Re: Tract N-1-B Watershed Subdivison - Sketch Plat Submittal

TRACTS N-1-B, WATERSHED SUBDIVISION zoned **PC**, located on **ARROYO VISTA** between **118TH ST** and **98TH ST** containing approximately 60.08 acre(s). (J-8)

Development Facilitation Team (DFT) – Review Comments

Planning - Case Comments

PRELIMINARY PLAT  
SAVIO RIDGE  
SUBDIVISION  
(REPLAT OF TRACT N-1-A & N-1-B  
WATERSHED SUBDIVISION)  
CITY OF ALBUQUERQUE  
BERNALILLO COUNTY, NEW MEXICO  
DECEMBER, 2024

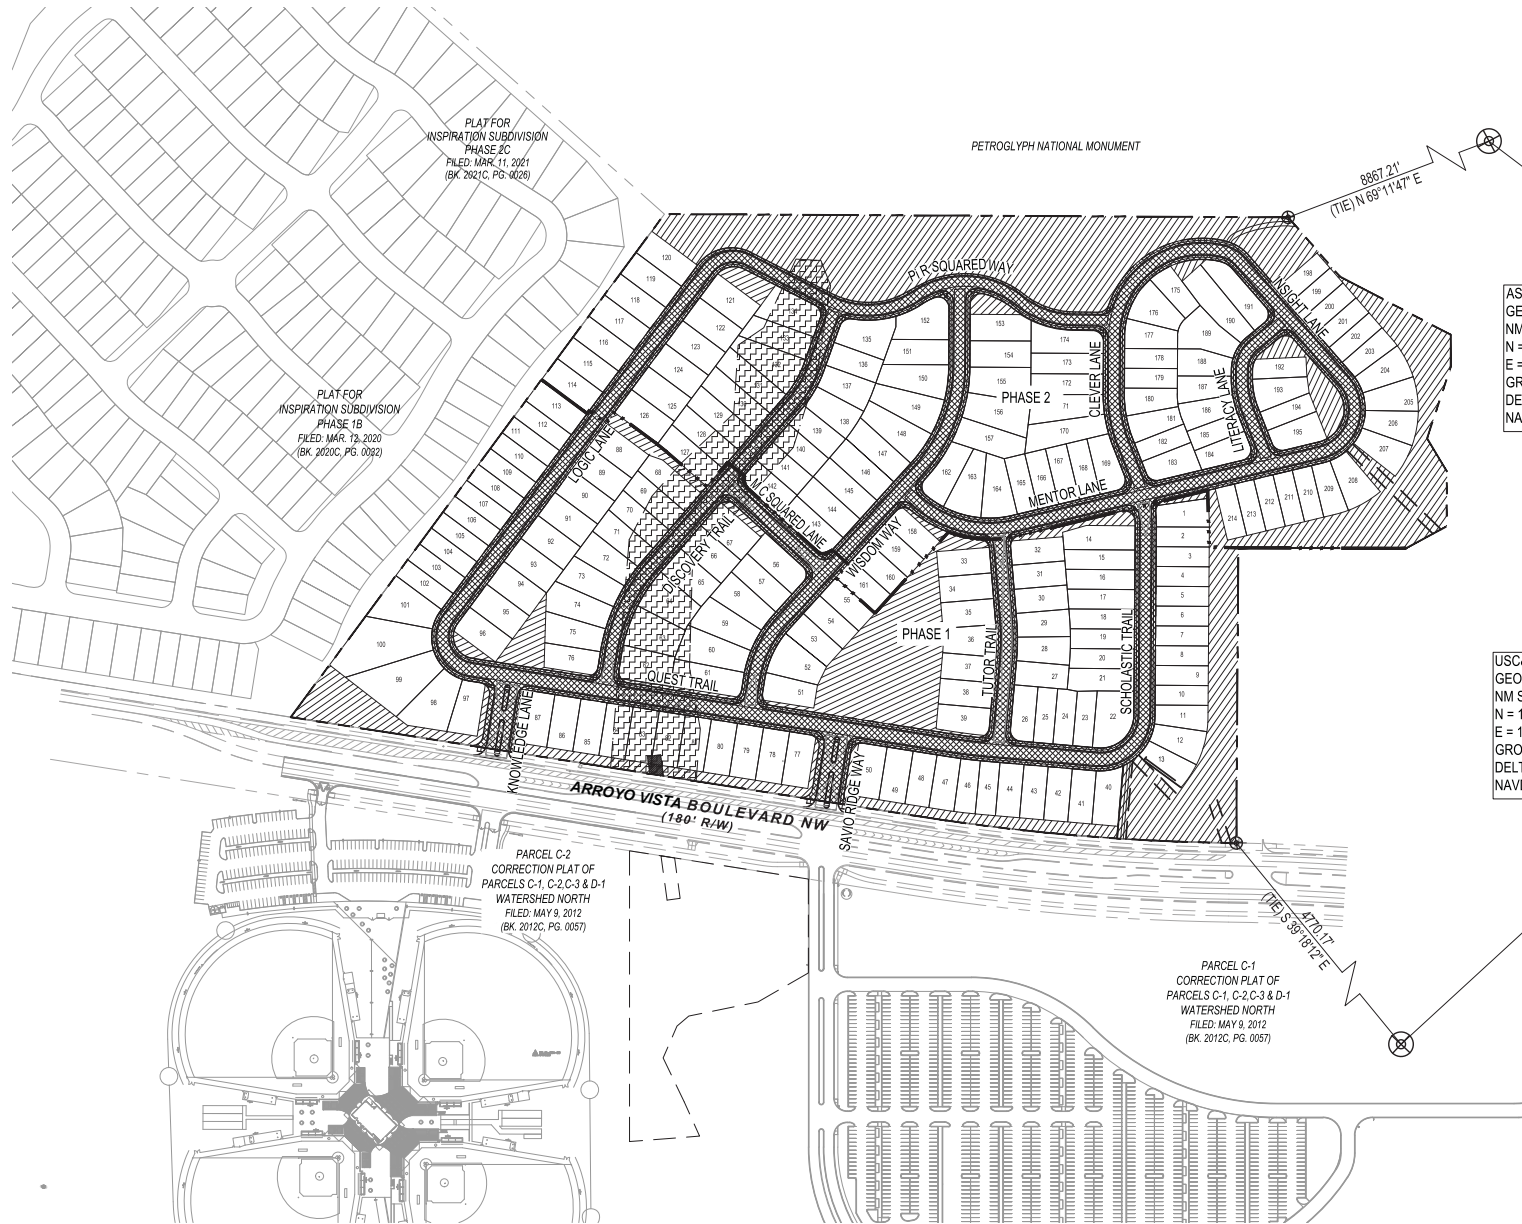
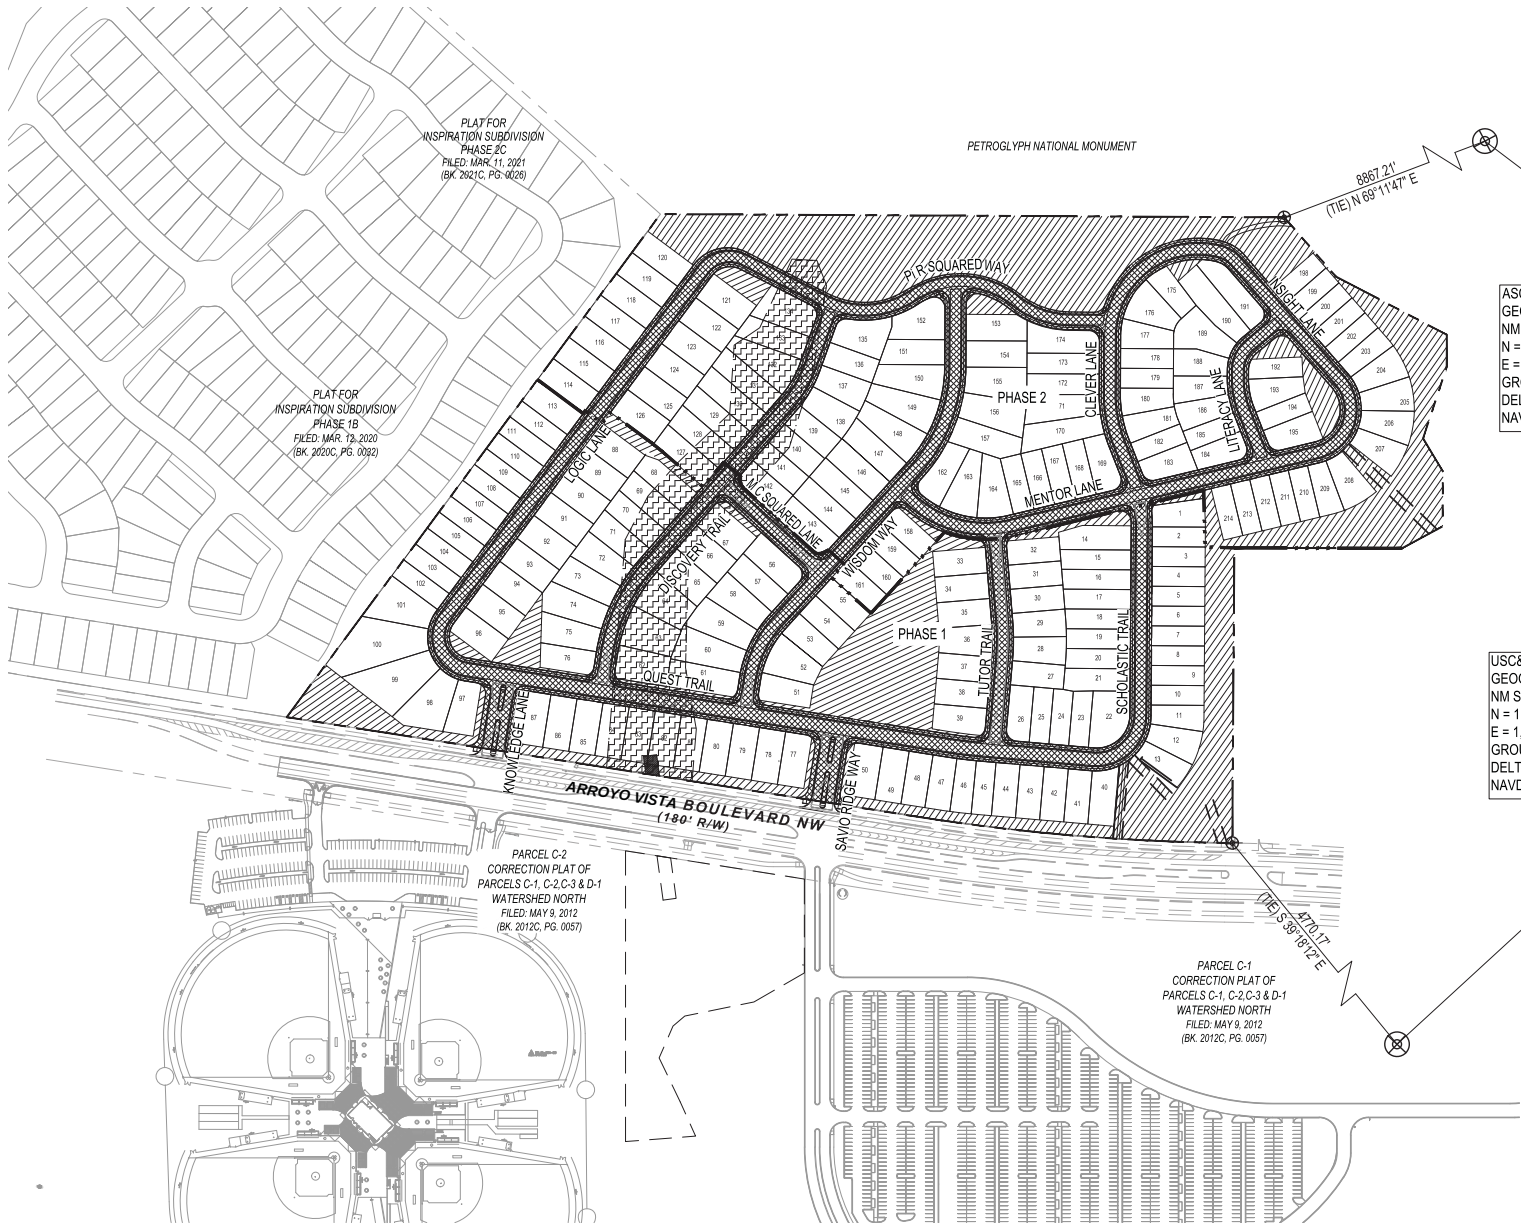
It is noted that a single-loaded street has been placed on the edge of the subdivision adjacent to Petroglyph National Monument which meets of the requirements of 5-2(J).

It would appear that you have been able to keep some block lengths under 600 feet, but some are not.
